## Wicklow County Council

RE: Referral Ref. ABP 320327-24

I refer to your letter of the 06/08/24 in relation to the above mentioned Referral. The Planning Authority considers that its reasons and considerations in relation to the submitted S5 Declaration Request are fully set out in its planning report and Declaration previously forwarded to the Board. However, the Planning Authority would like, in the interests of clarification, to comment on the submitted Referral as follows.

Structure 05

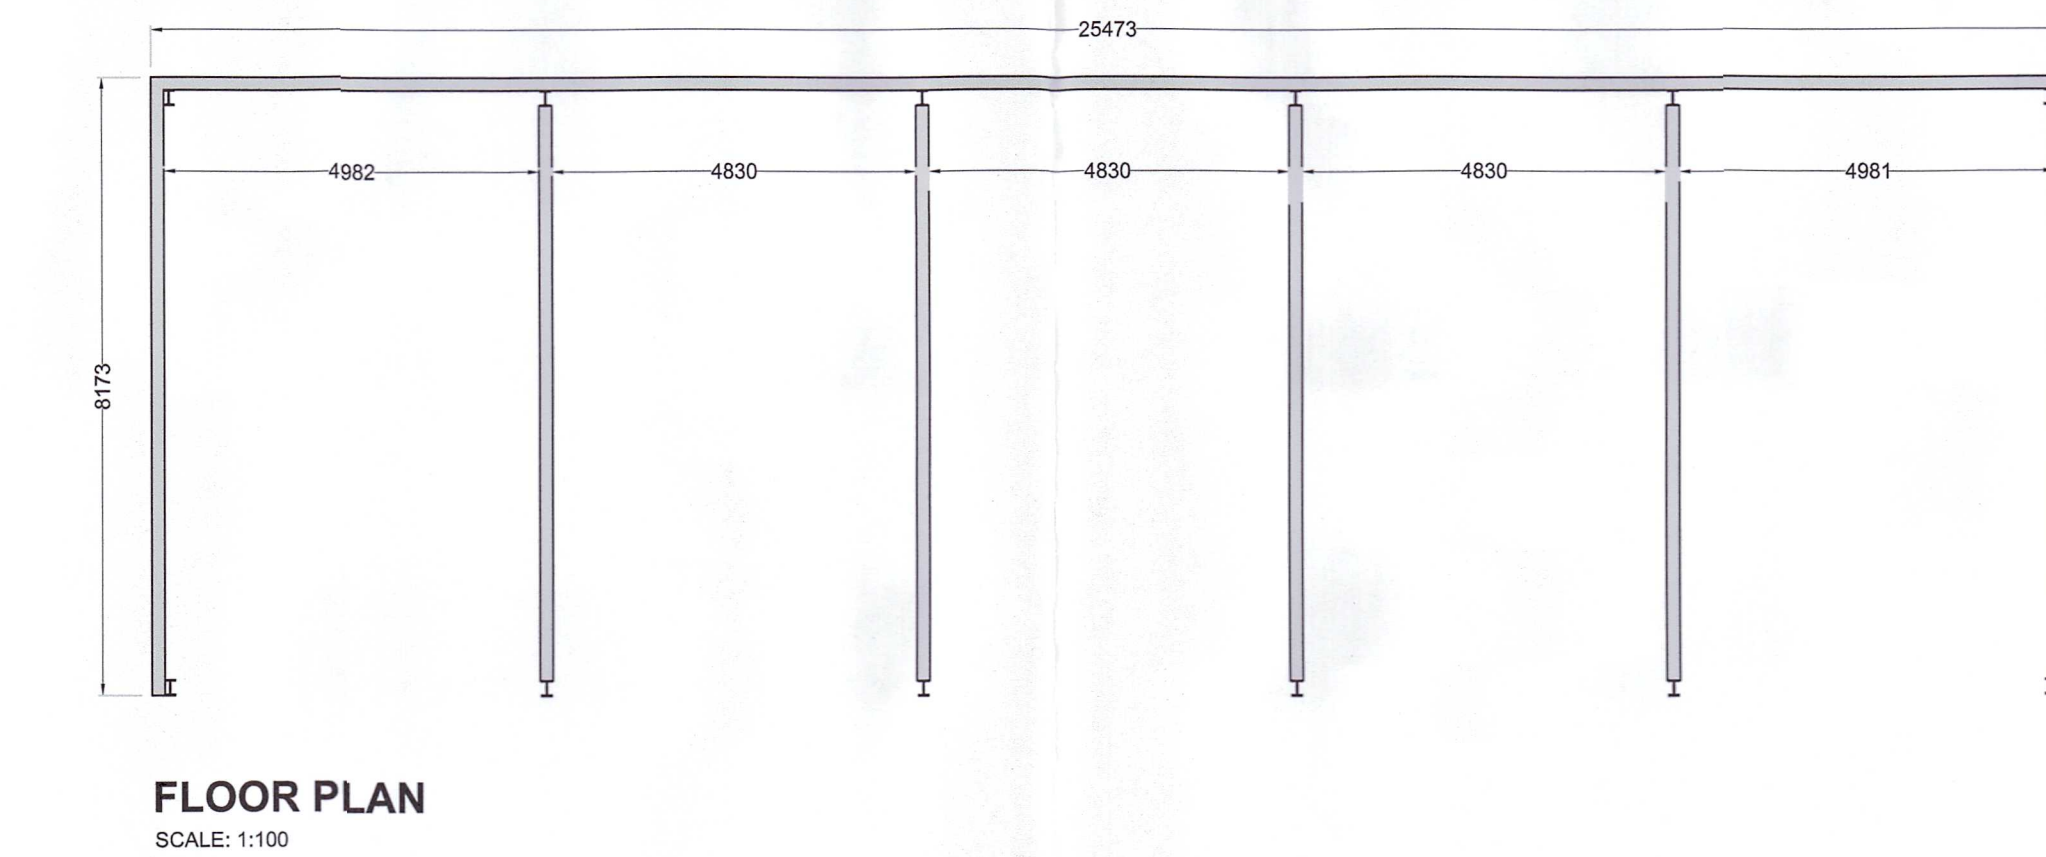
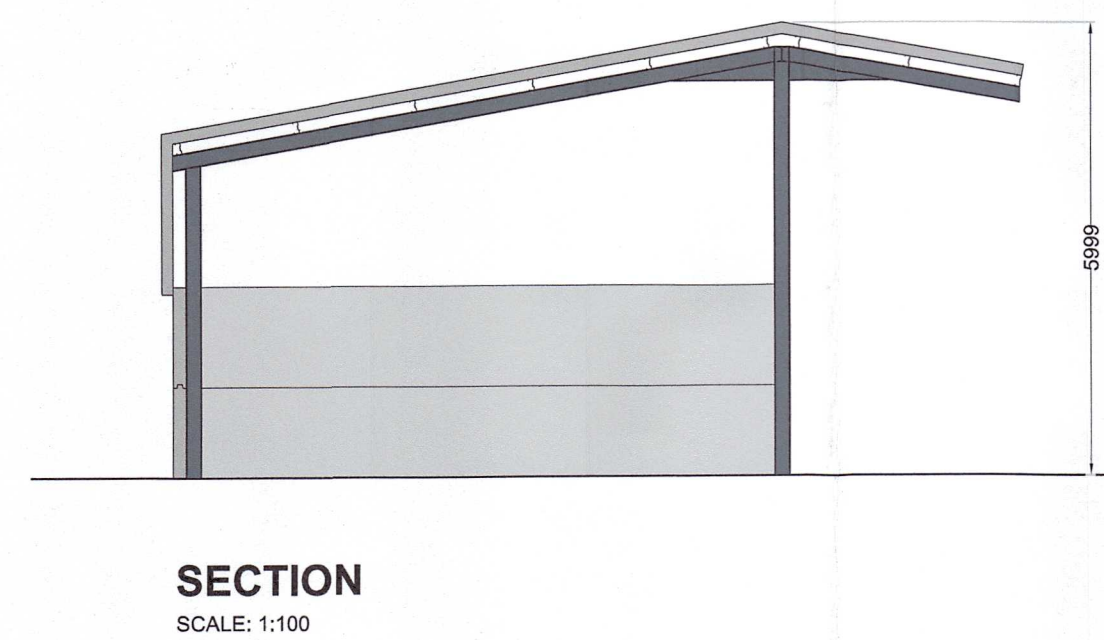
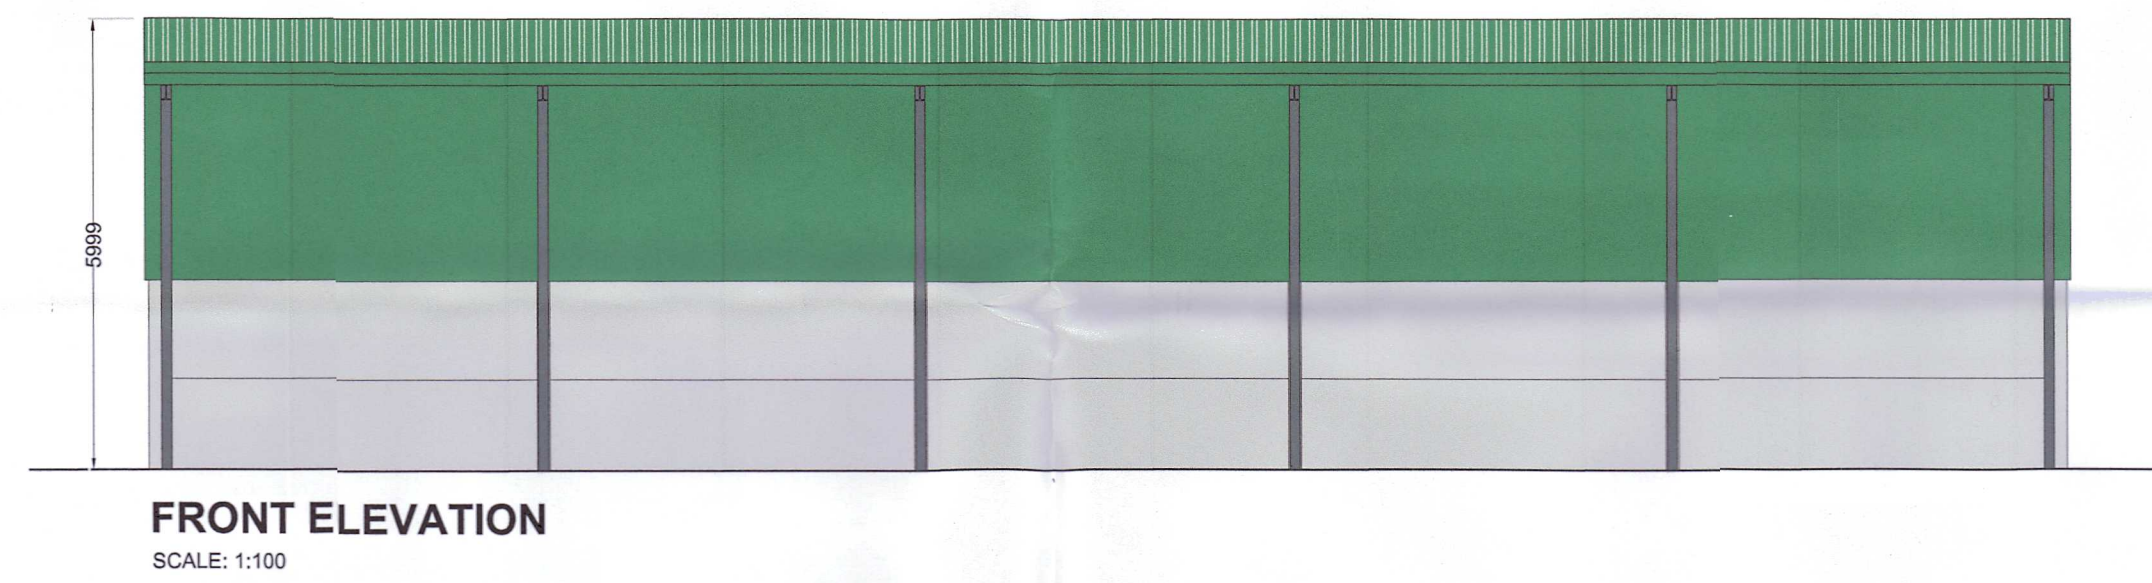
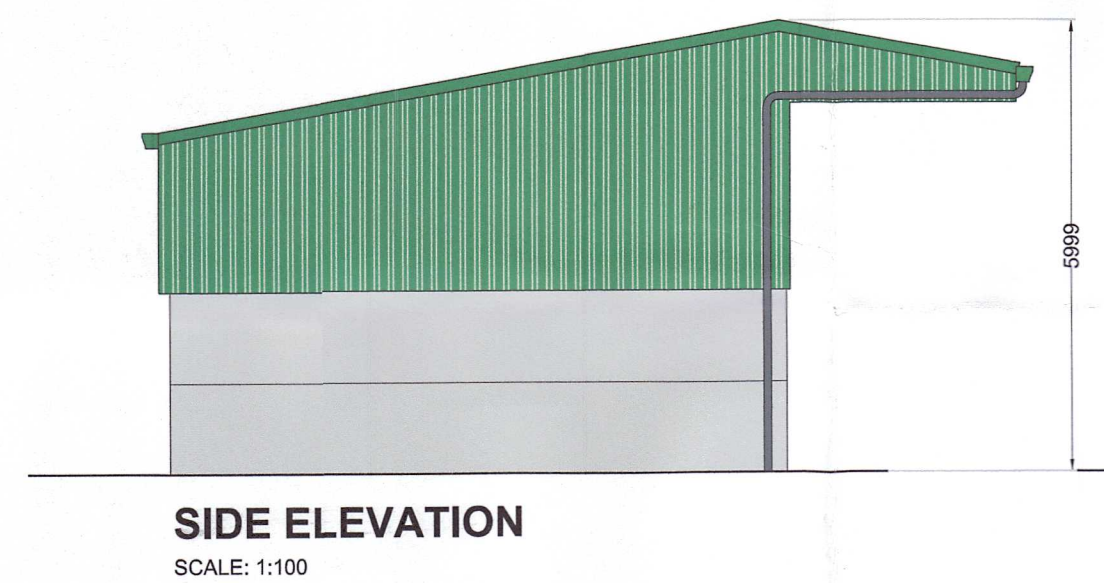
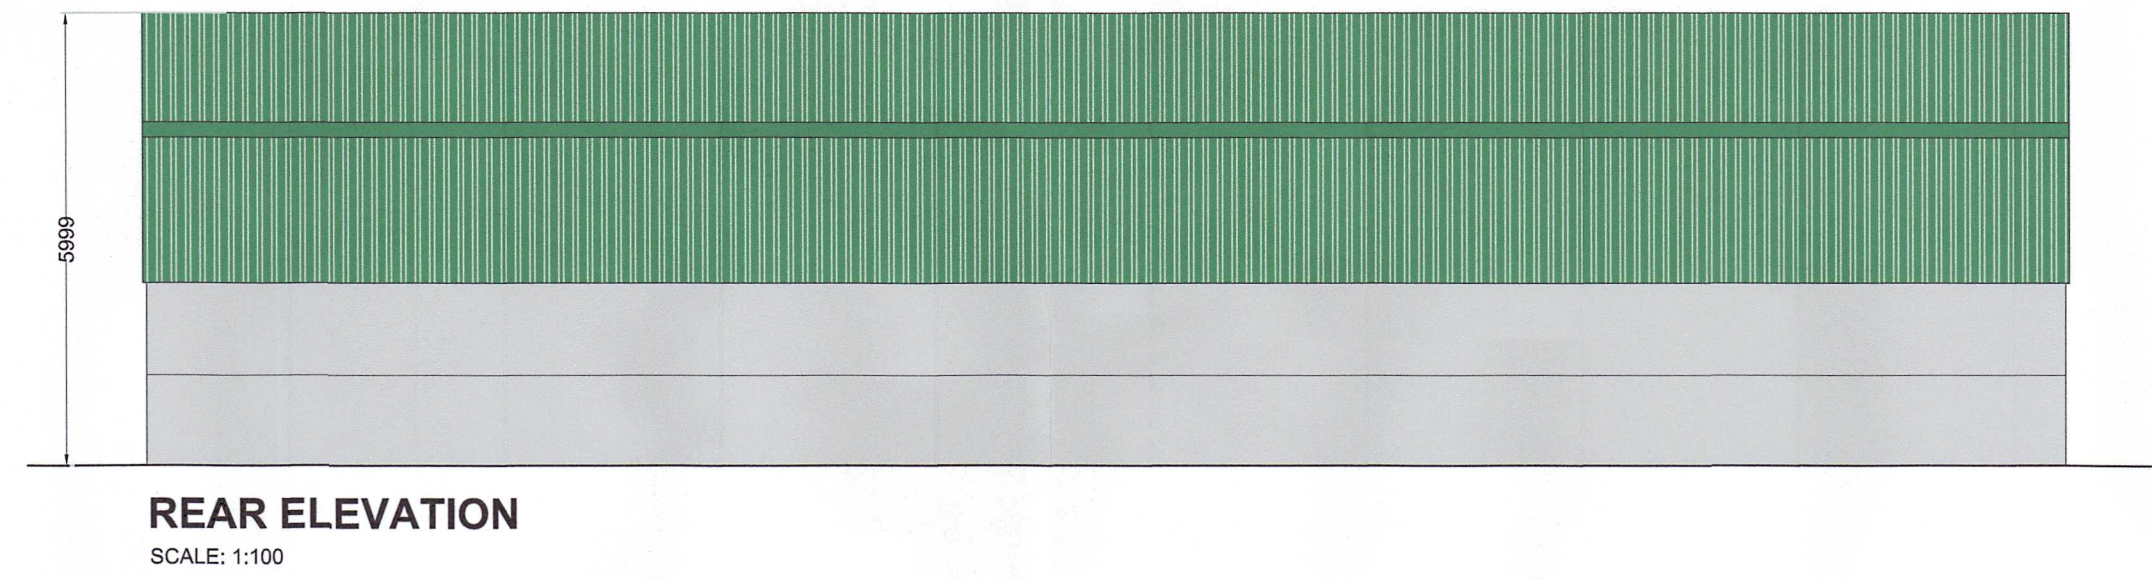
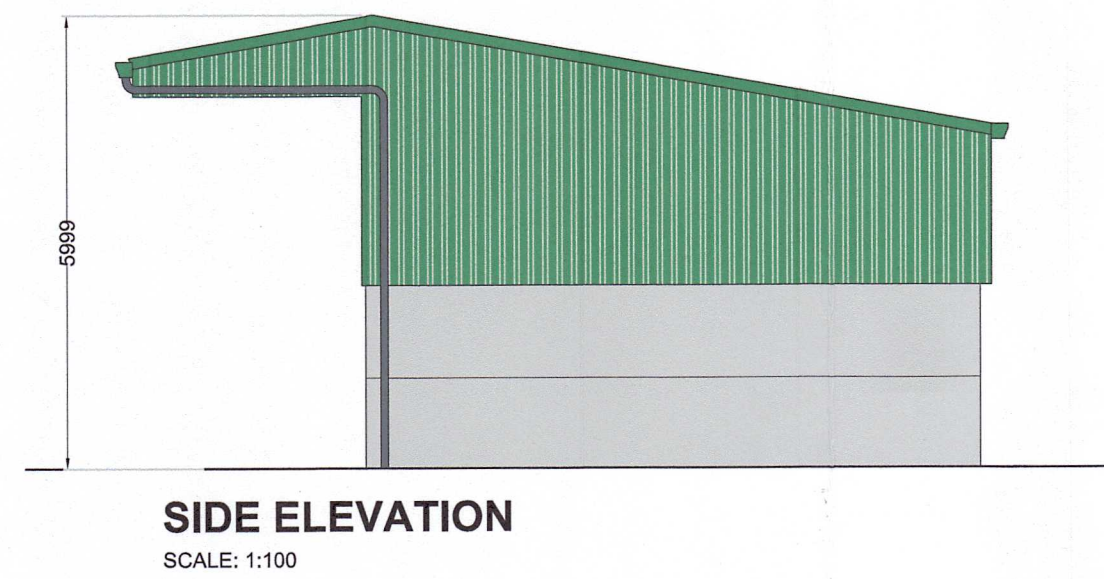
The comments under the above headings re aggregation are relevant.

CLIENT	Tondo Ltd.		
JOB TITLE	Development at Kippure Estate		
LOCATION	Manor Kilbride, Blessington, Co. Wicklow		
STATUS	Pre-Planning		CHECKED AB
DRAWN	NF		APPROVED AB
DRAWING No.	PL-0708-01-KE	DRAWING TITLE	REVISION
		Structure 07 & 08

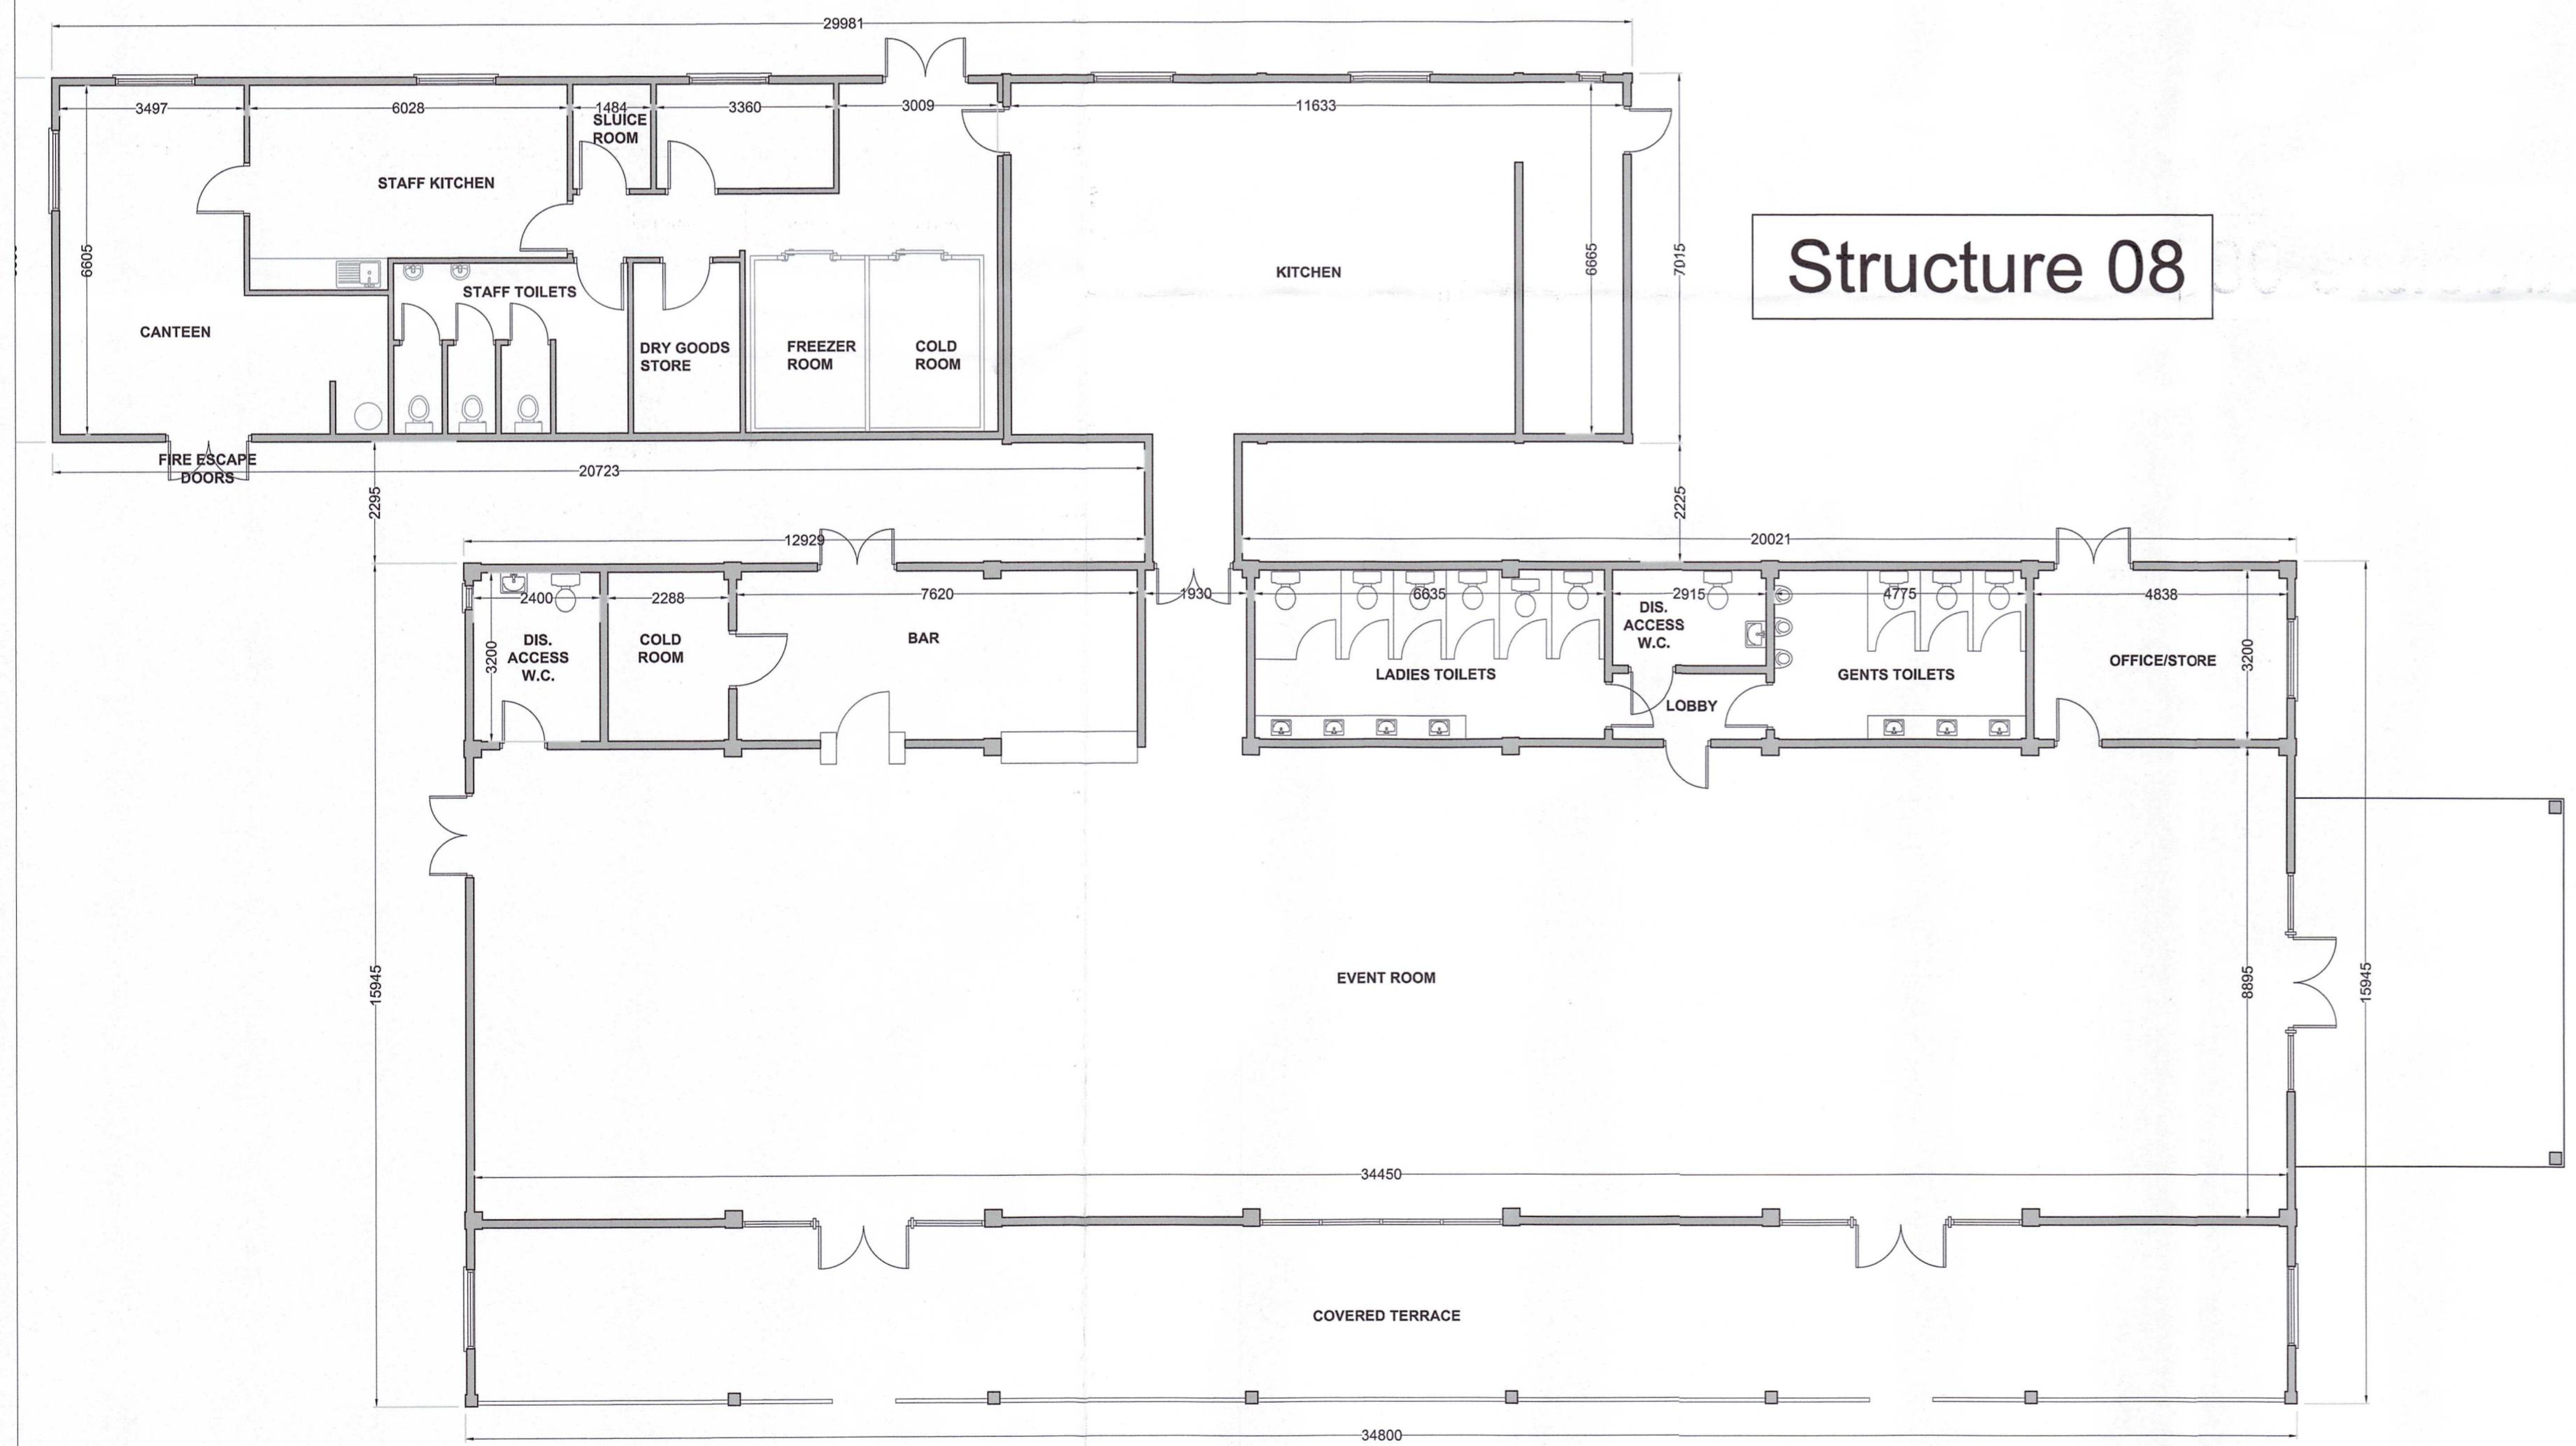
The Referrer's statement re the basis of the Planning Authority's determination re Structures No. 7 & 8 is inaccurate.

It is not clear why a request for further information was necessary to clarify incorrect statements made as part of the S5 Declaration Request.
